# 12360 - North Penrith Stages 2B & 2C Development Application

## RESPONSE TO AGENCY SUBMISSIONS

NORTH PENRITH
STAGE 2B & 2C
WATER FEATURE
SECTIONS

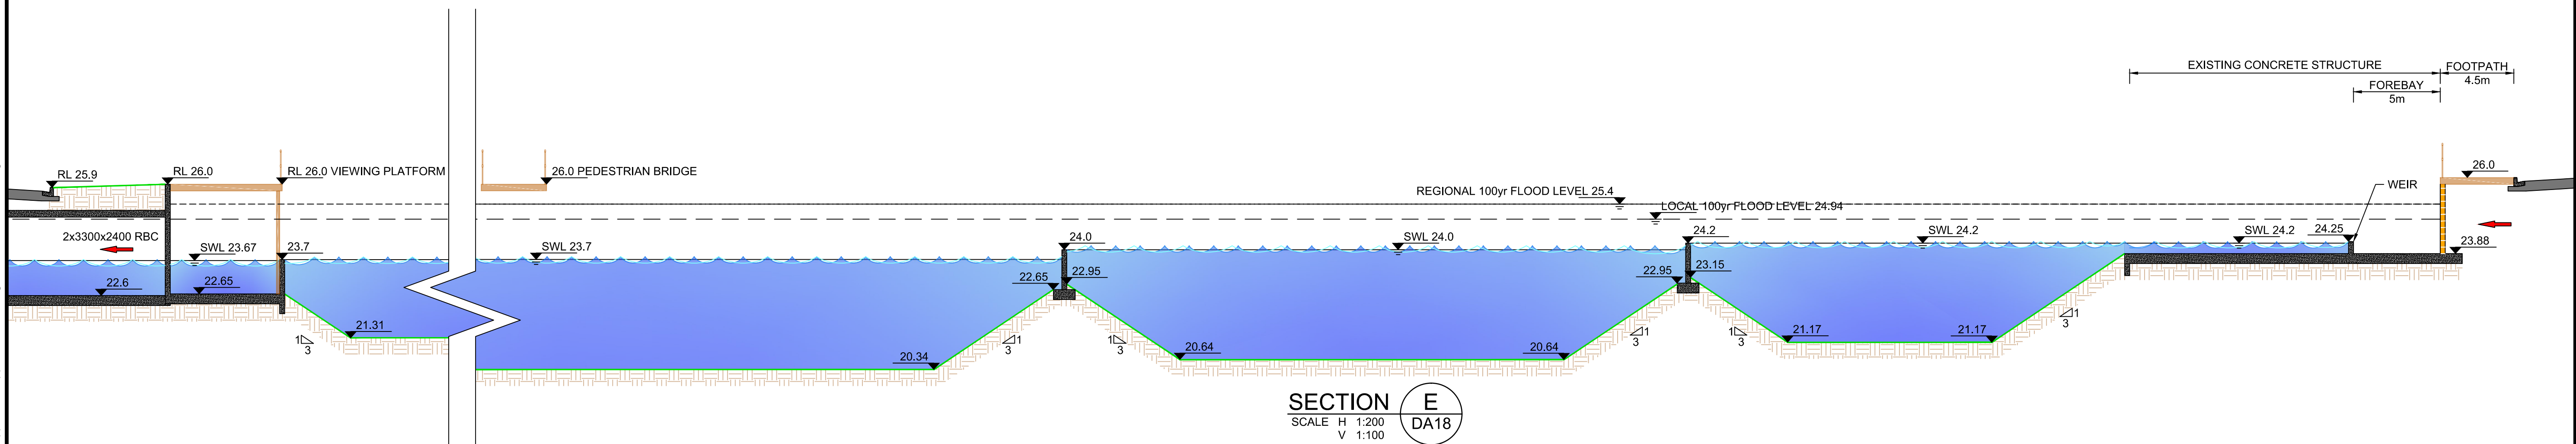
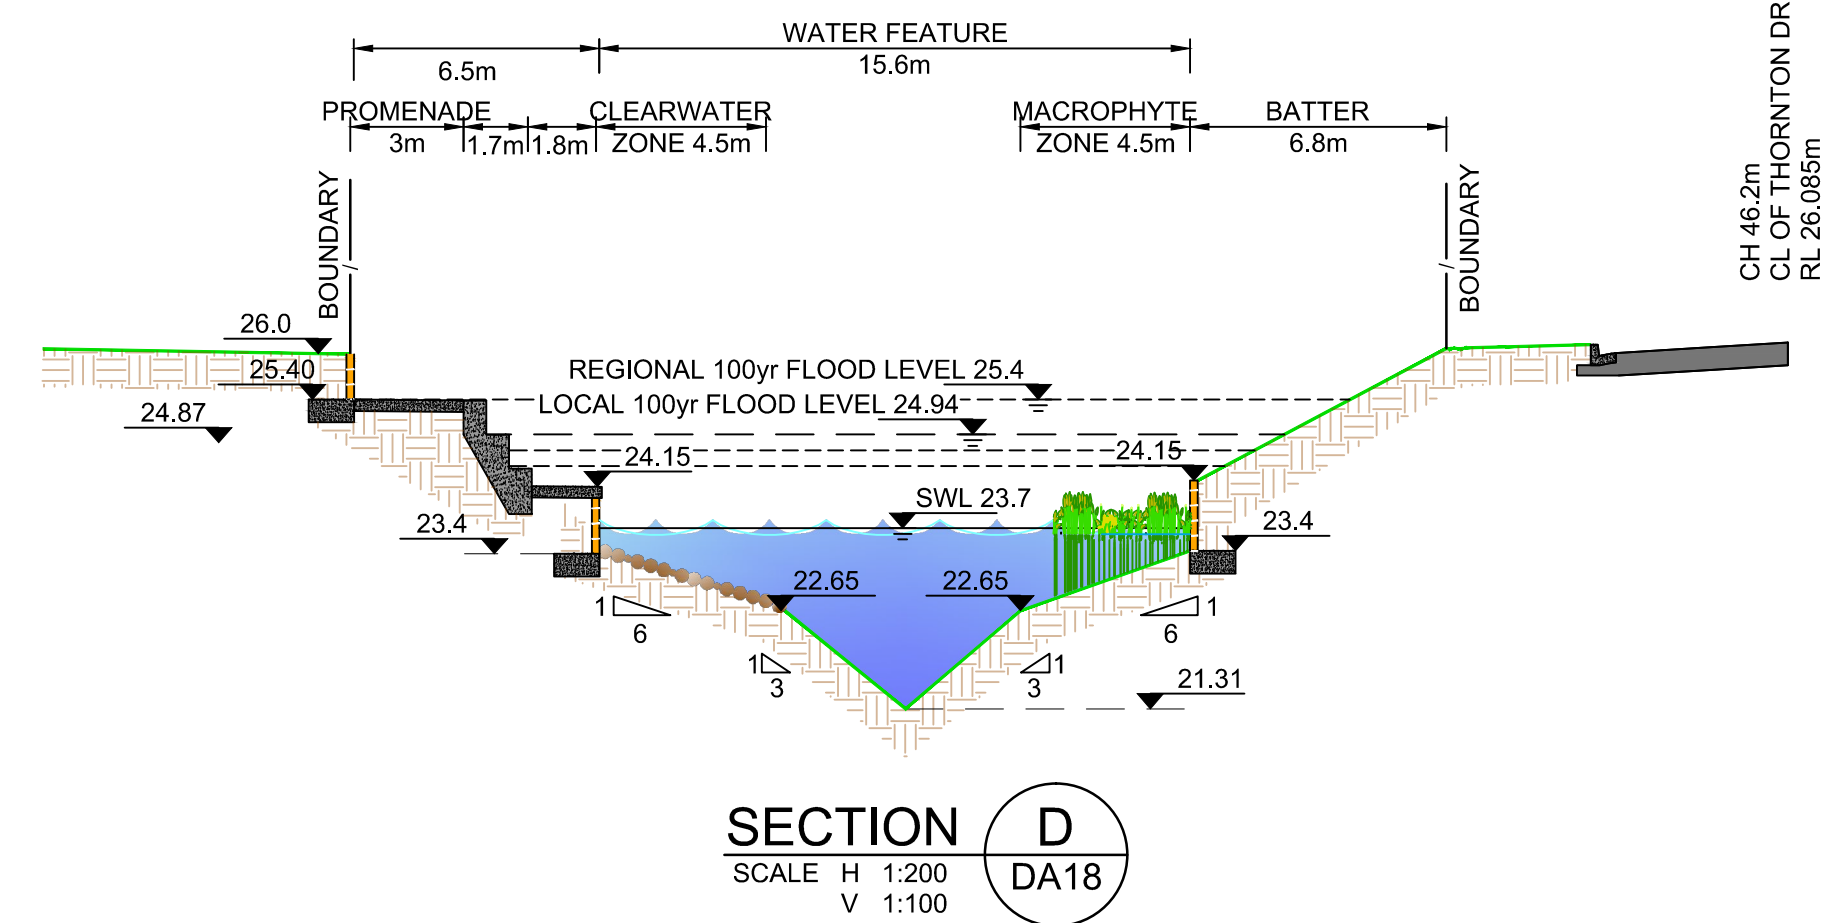
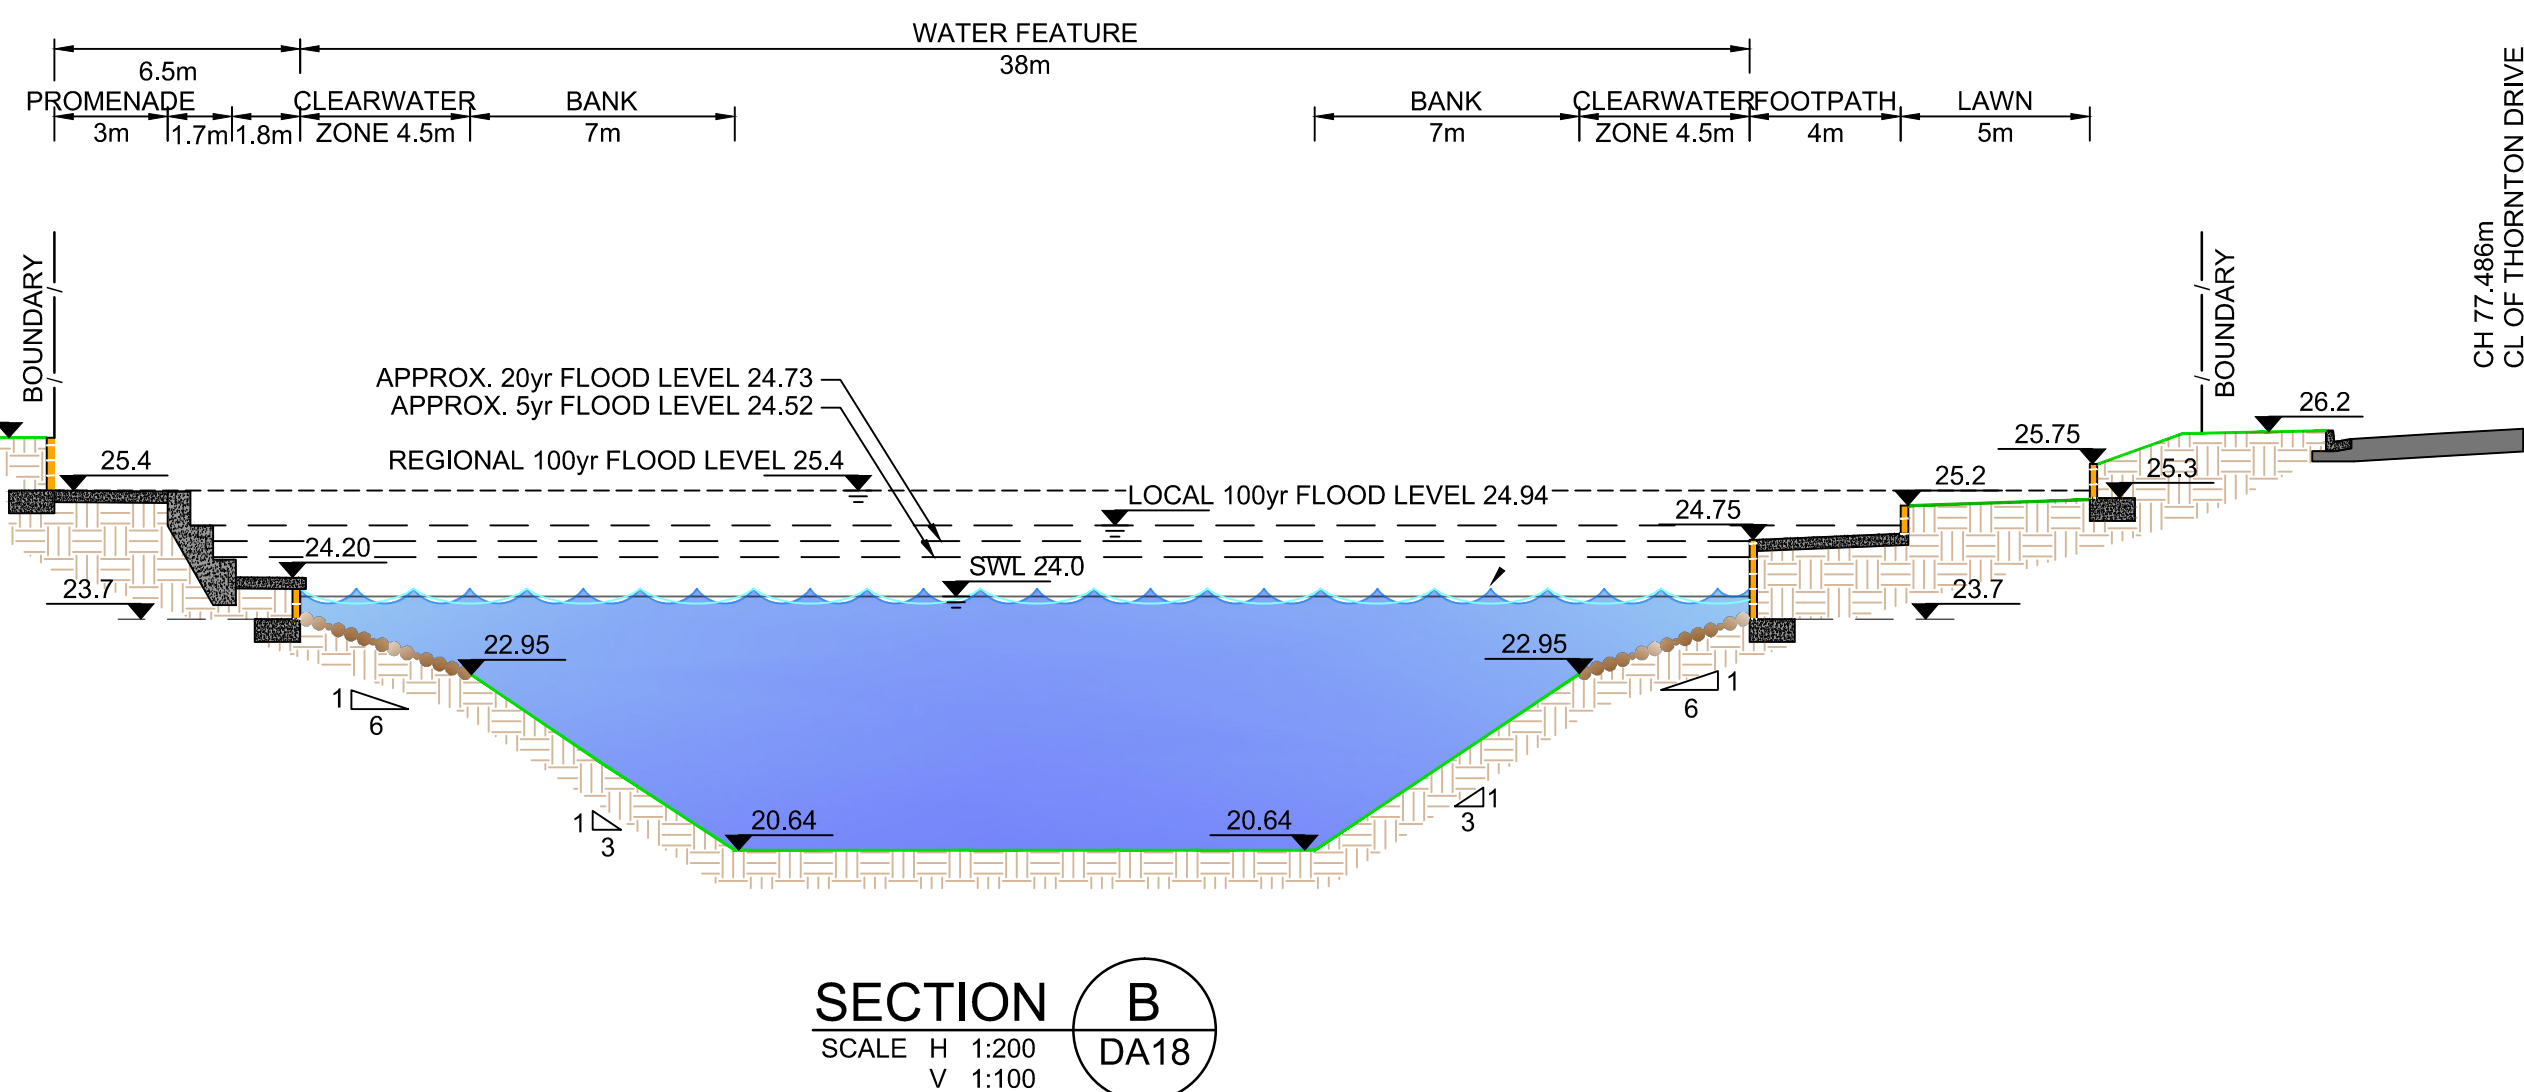
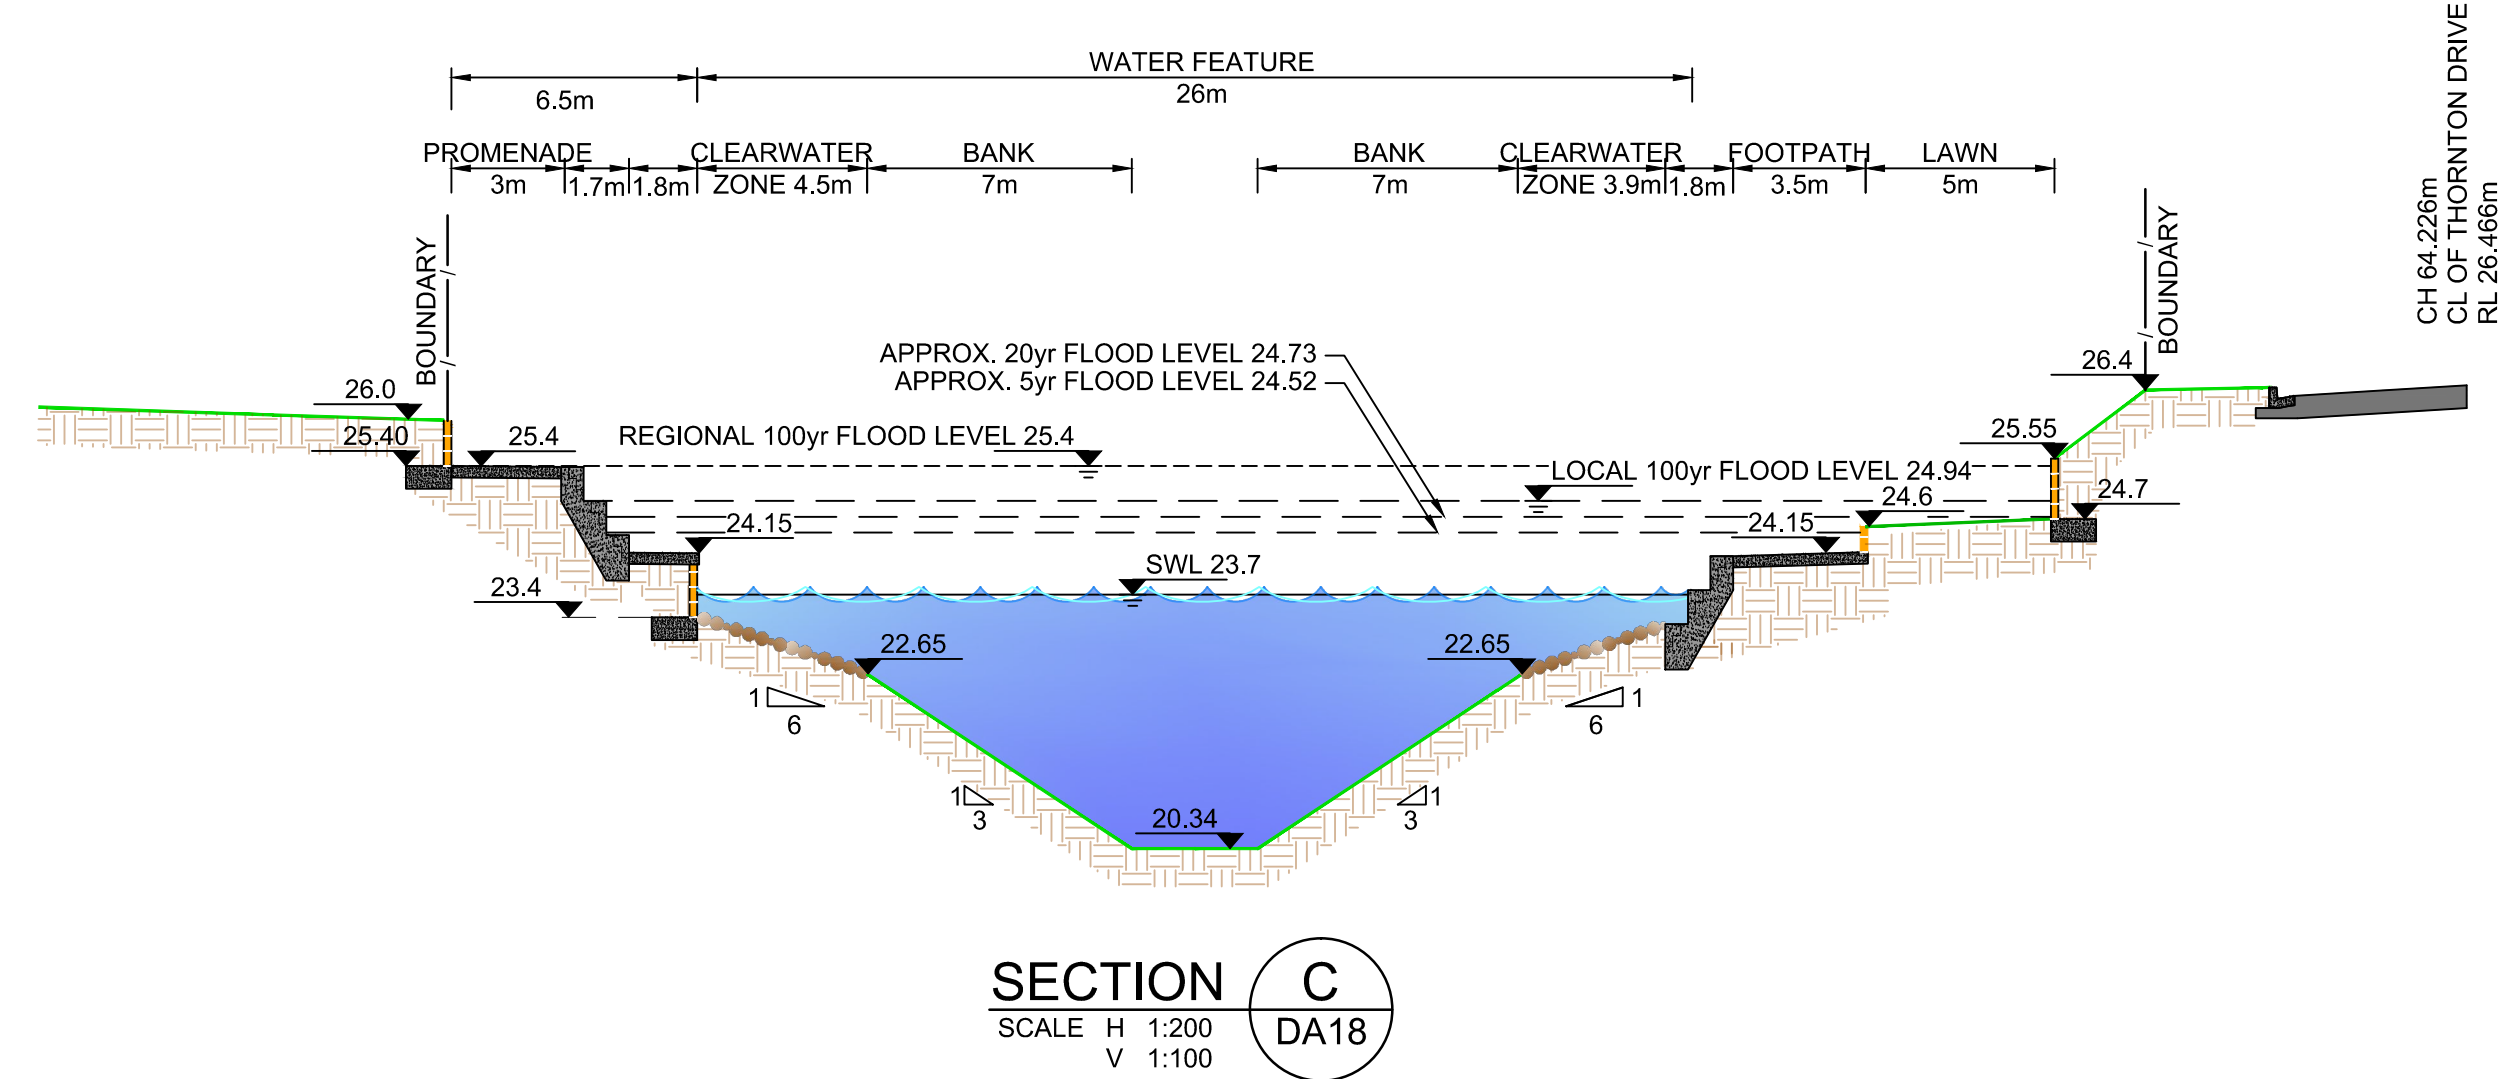
<ul style="list-style-type: none"> <li>The proposed channel is likely to have limited water quality benefits due to its design and lack of vegetation.</li> </ul>	<ul style="list-style-type: none"> <li>The central water feature and wetland have been designed as an integrated system to meet relevant water quality targets, as detailed and confirmed by the Water Cycle Management report.</li> </ul>
<ul style="list-style-type: none"> <li>There is likely to be an issue with sedimentation of the channel which will ultimately result in long term management issues with regard to algae growth. Detention ponds such as the one propose are commonly associated with algae management and unwanted vegetation management issues. The proposed water reticulation system and reliability of aerators will be critical to effective management of the canal and failure would likely result in management issues.</li> </ul>	<ul style="list-style-type: none"> <li>The inclusion of GPT's at all discharge points into the central water feature will reduce the sediment load entering the system. The system has been designed with best practice management principles and is considered to be a robust and functional system to manage algal growth.</li> </ul>
